From: Brian Greenwood [<mailto:Brian.Greenwood@osborneclarke.com>]
Sent: 15 January 2015 17:51
To: Port Talbot Power
Subject: EN010062: Tata Steel DCO - Written representation of Associated British Ports (10030077)

**Application by Tata Steel UK Limited for the
Port Talbot Steelworks (Power generation Enhancement) Order
Written Representations of Associated British Ports (ABP) – Ref 10030077
(Deadline 1)**

- 5.1 As noted above, ABP does not object to the principle of the construction of a new power station designed to service the Tata steel works. That said, however, ABP does object to any proposal which would or which could have the potential to impact upon the current or future operations of the Port – thus the position it has been bound to adopt at the commencement of this NSIP process.
- 5.2 In Document 5.04 of the Applicant's Environmental Statement (ES) - **Details of Other Consents and Licences** - the Applicant indicates at section 11- "Permit to pump" that "Applications will be made as required by the MWC."

Figure 14.2.4 Port Talbot Dock simulated level time series plot for whole simulation period. Run 2 – Scenario 1 Current Operations.

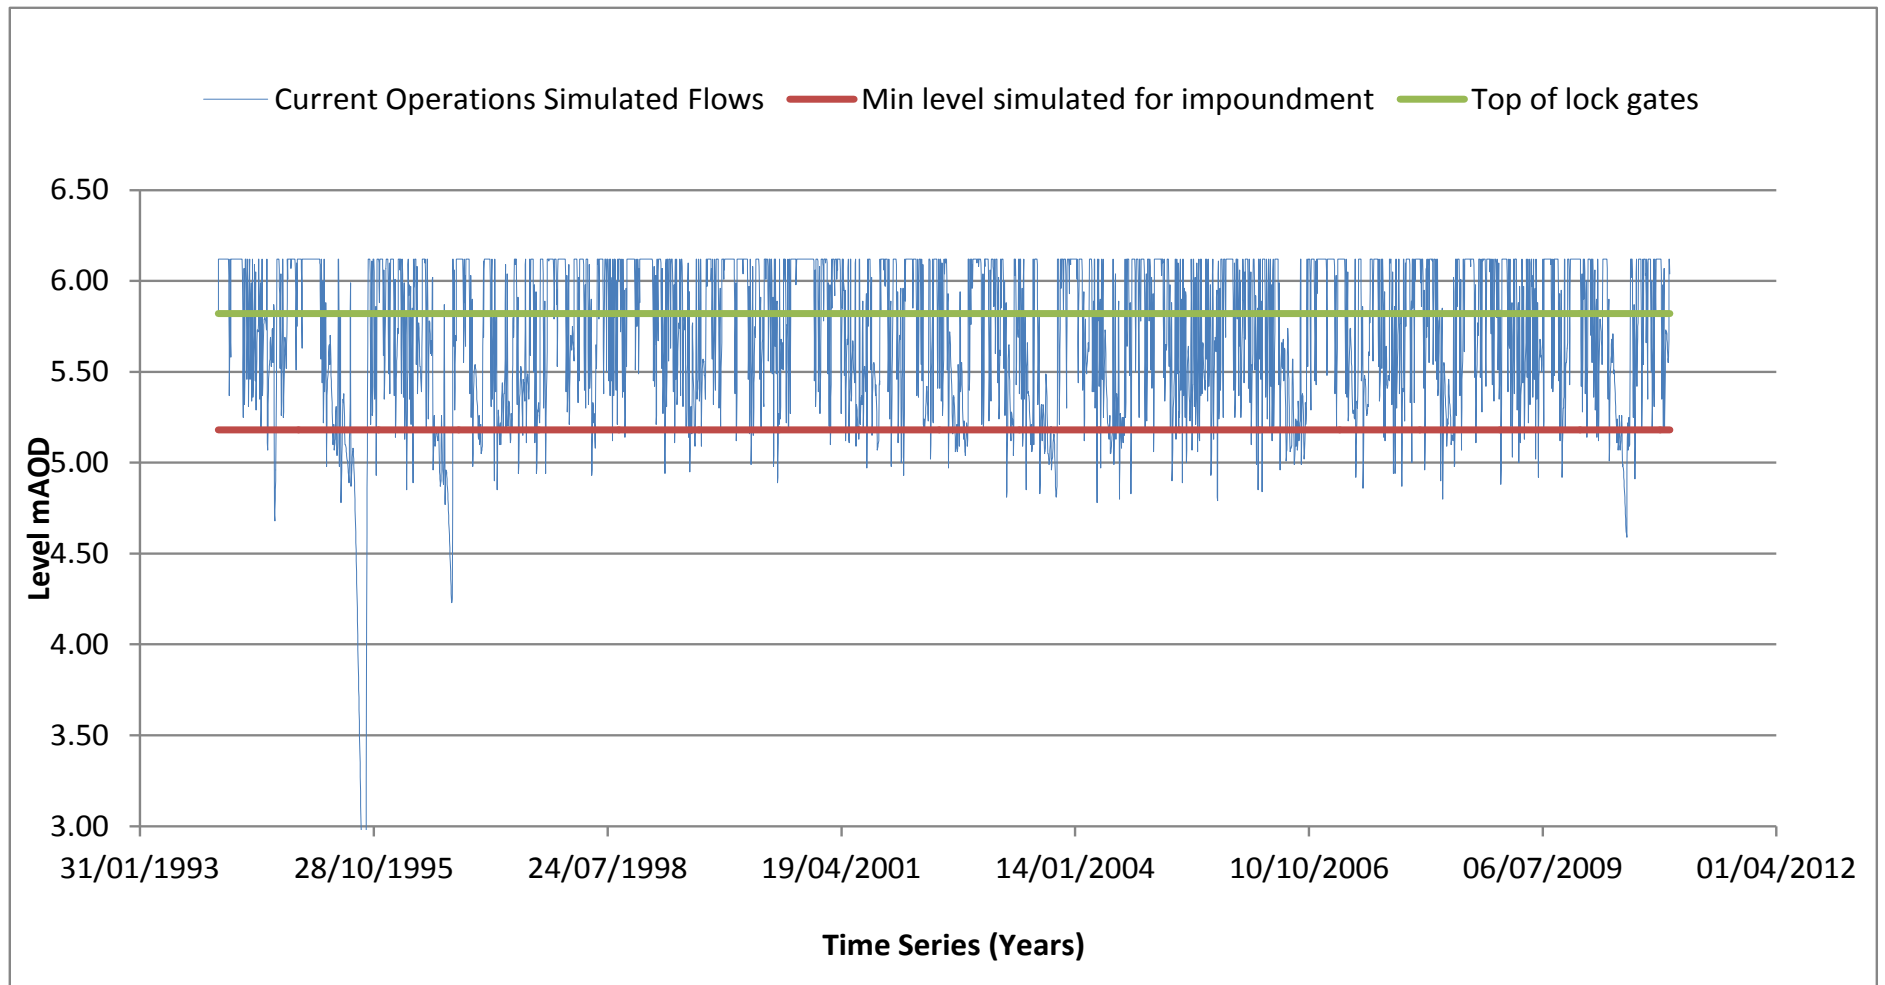
- 5.7 At para 14.3.23, however, the Applicant concedes that the water balance modelling did in fact produce “anomalous results” as a consequence of which the potential effect of the proposed new abstraction regime on both the River Afan feeder and the Dock’s water levels has had to be based on a number of assumptions. This of itself is of some concern to ABP as the operator and owner of the Port.

- 7.8 At the same time, however, there will be an increase in consumptive abstraction from the River Afan Dock feeder channel of 5,000,000 m³/yr which the Applicant accepts will - *"decrease the amount of water reaching the dock from the feeder channel."* (Para. 14.7.23). and that overall, this is likely to lead to a decrease in water levels within the Dock (para. 14.7.24).

- 7.9 This, together with the anomalous results obtained in the modelling, has led the Applicant to draw the conclusion that it is - *"logical to expect that the improvement works will maintain the level in the dock above the level established for the worst case scenario and the dock level will not decrease with the improvement works in place (even with the net changes to consumptive abstraction from the River - Dock system) as the refurbishment of the locked gates would mean that much less water would be lost through gate leakage than is lost at present. Therefore, it has been assumed that for the best case scenarios no adverse effects on dock level will occur as a result of the proposed development beyond that established in the worst case scenario."* (para. 14.7.26).
